Department of Planning and Environment

**Alexandria Park Community School Redevelopment-Mod-3 (SSD-8373-Mod-3)
Request for additional information**

I refer to the Alexandria Park Community School Redevelopment Modification Application 3 (SSD-8373-Mod-3). The Department of Planning and Environment (Department) has undertaken an assessment of the proposed modifications and has identified that additional information is required, as detailed below.

**DRAWING TITLE**  
FINISHES & LEVELS PLAN 2a OF 8

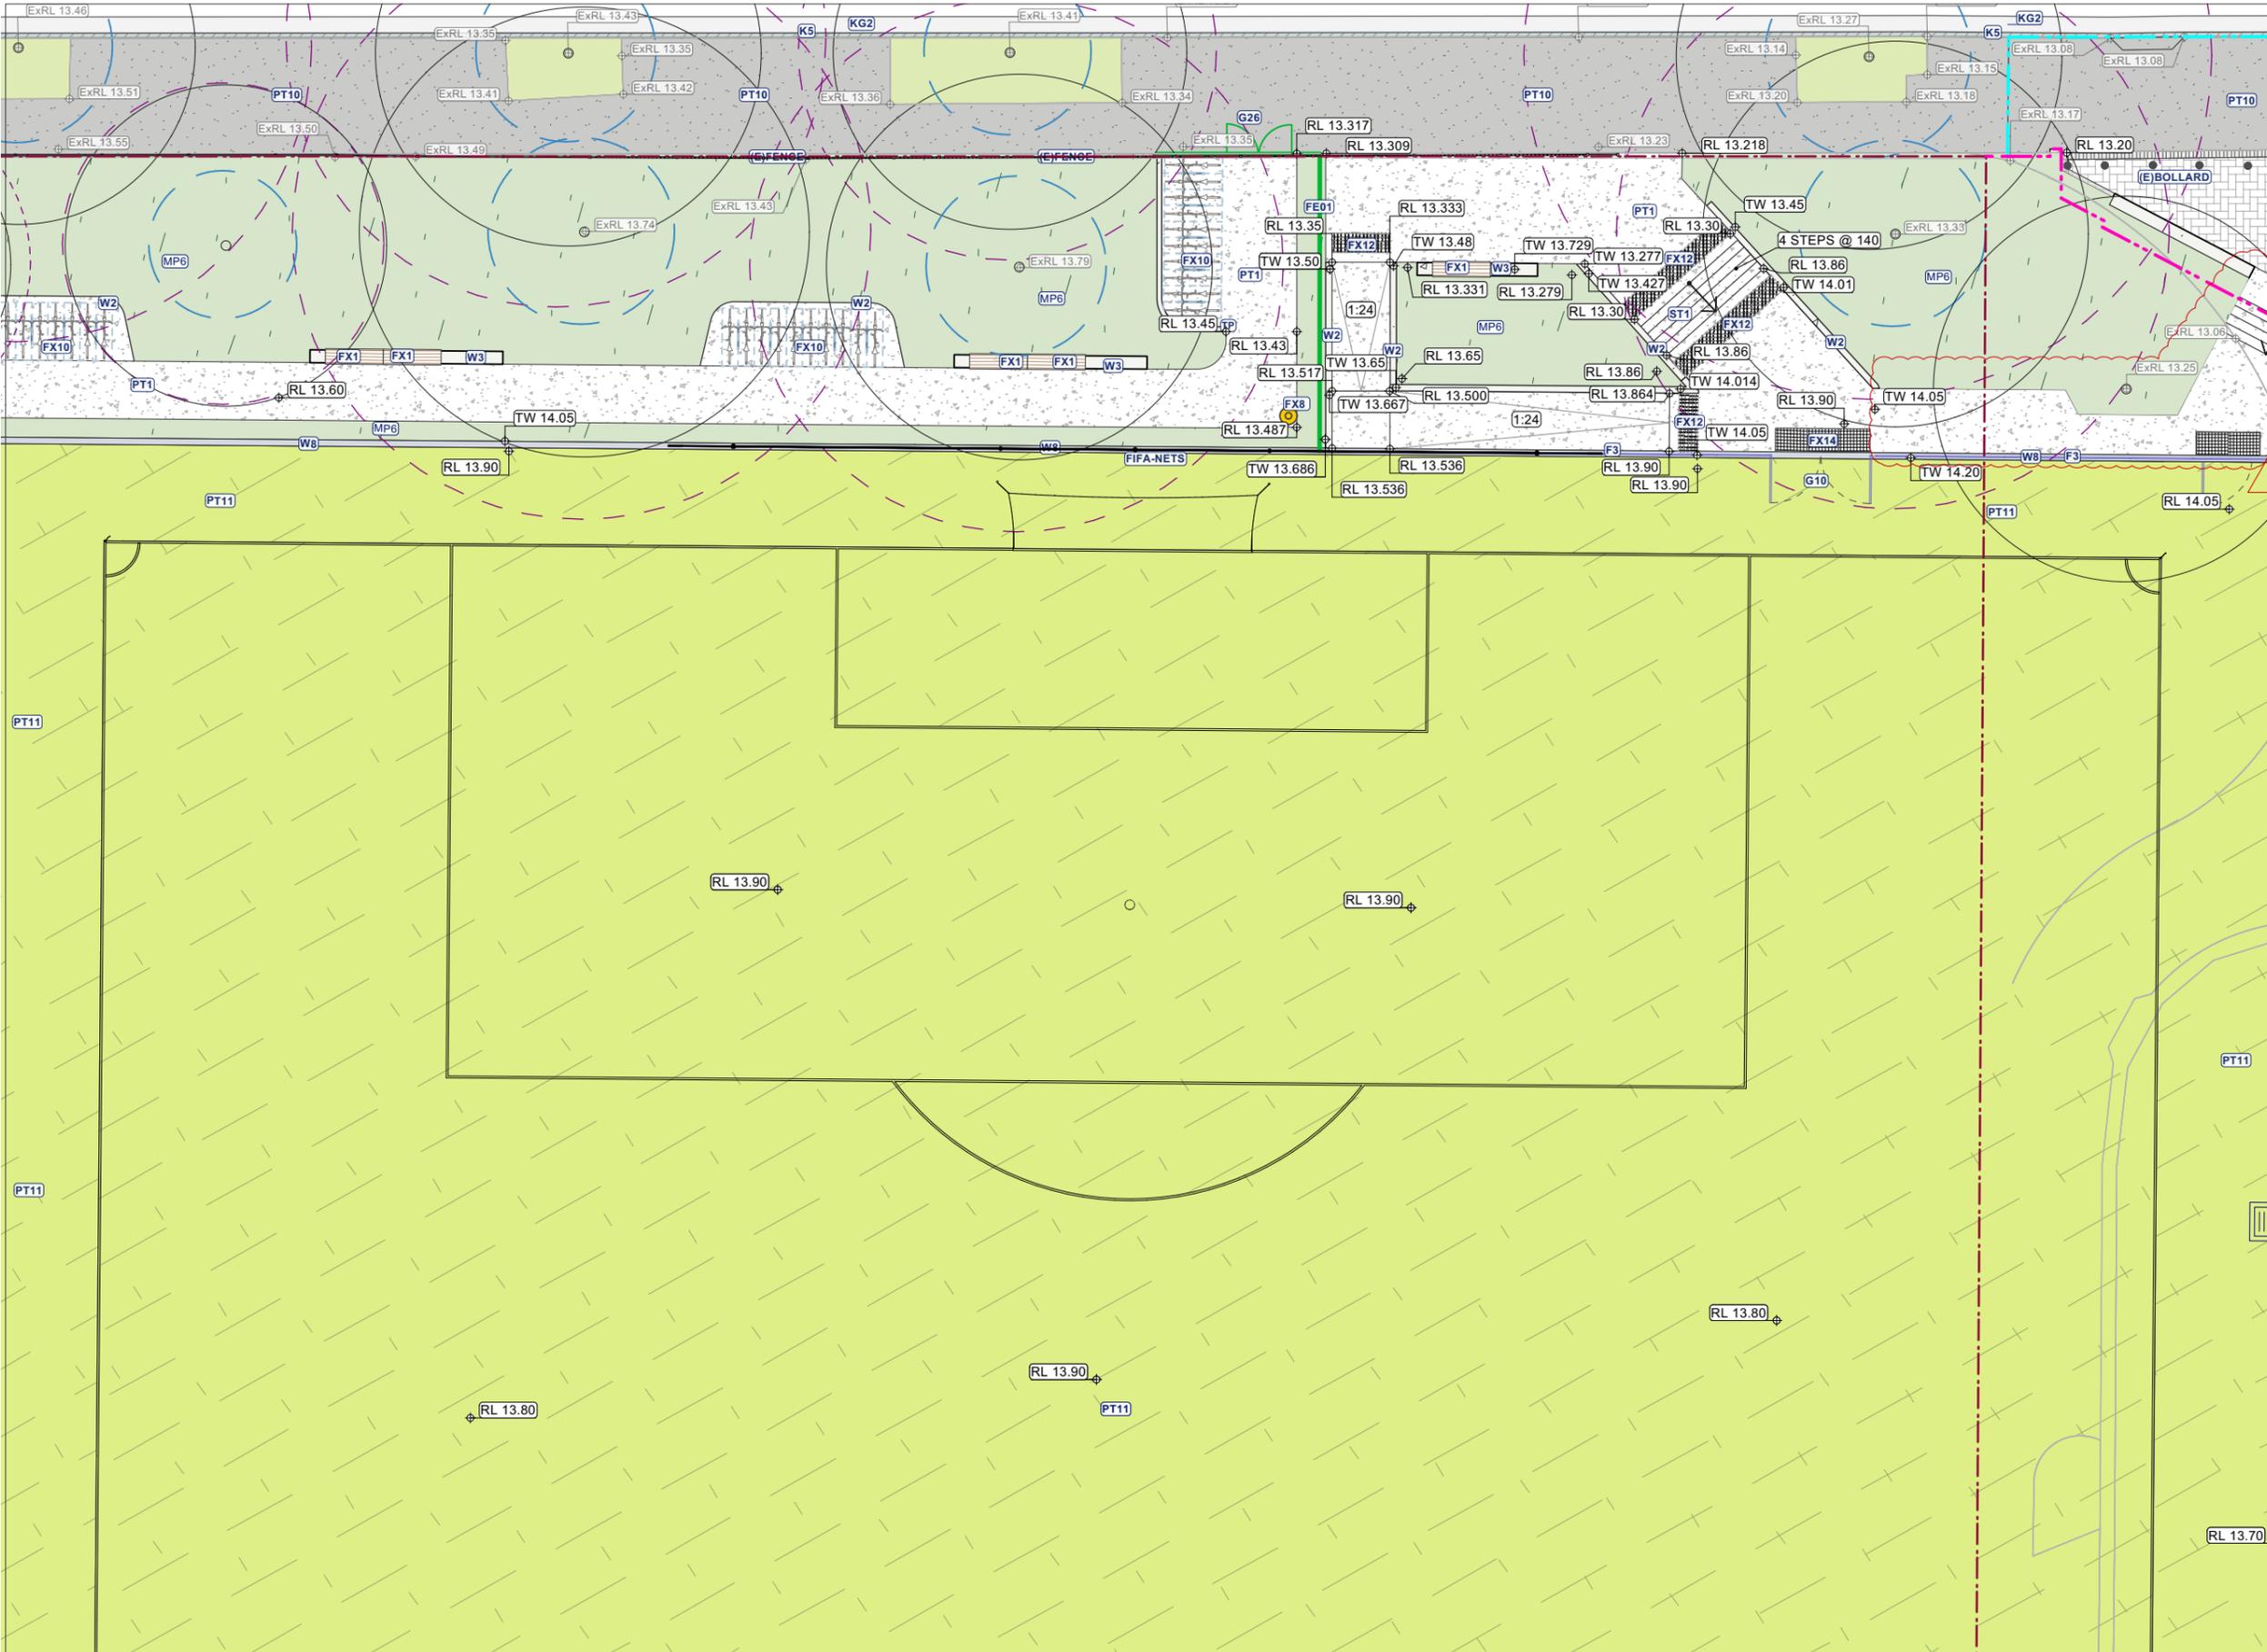
Additionally, not addressed in the modification report, but indicated in the architectural and landscape plans, are eight new trees along the eastern boundary of the multi-purpose sports field. Clarification is required as to whether these trees form part of the modification application. In the instance that these trees are confirmed to be part of the application, written evidence must be provided demonstrating that the relevant owners consent has been received.

- an assessment of the proposed modifications (including proposed trees where relevant) undertaken by a suitably qualified person, which addresses all matters related to heritage for Alexandria Park and the Alexandria Park Conservation Area.
- the relevant 'materials schedule' referenced in the landscape plans must show the materials and finishes to detail both stairs subject to this modification.
- where additional trees are proposed, the tree plan and tree schedule as required by condition A29 must be updated.

Drawing Title  
**PROPOSED SITE PLAN -  
COMPLETED PROJECT**

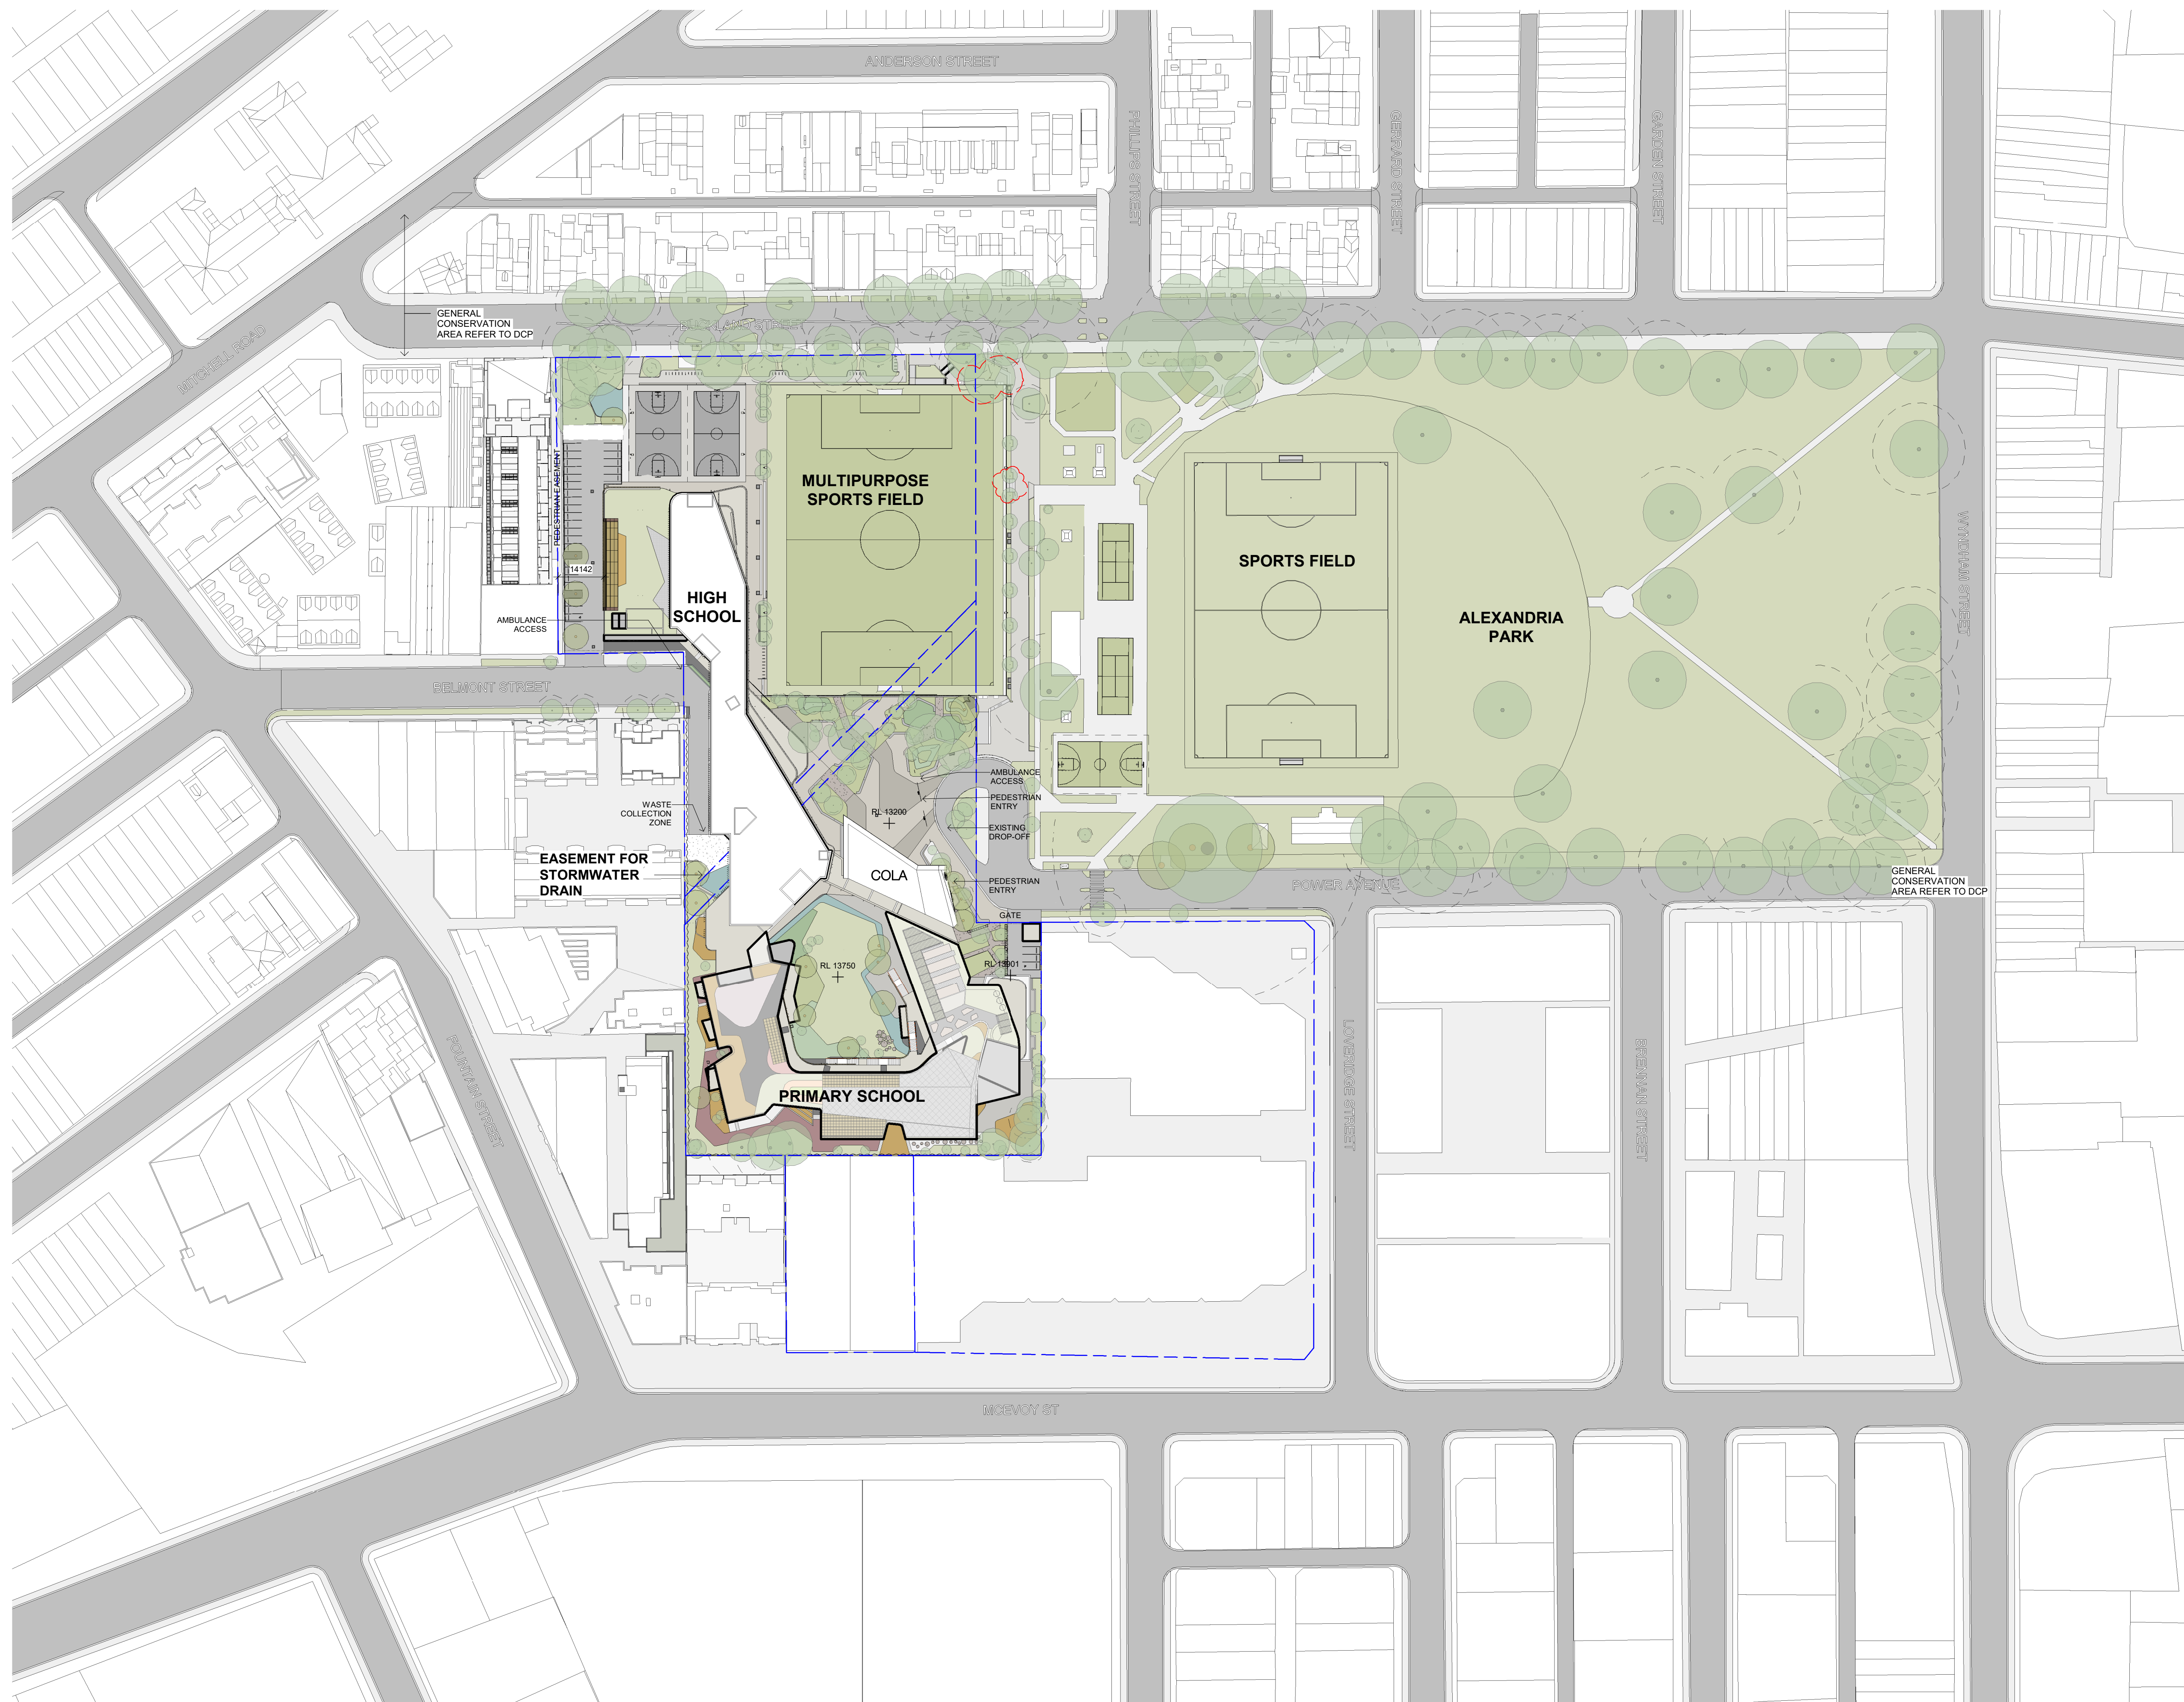
The modification report briefly states that the proposed new and amended stairs from the multi-purpose sports field would not have detrimental impact on the neighbouring heritage item (Alexandria Park) or on the Alexandria Park Conservation Area. No consideration has been given to the fact that some of the proposed modifications would be within the boundary of the Alexandria Park Conservation Area.
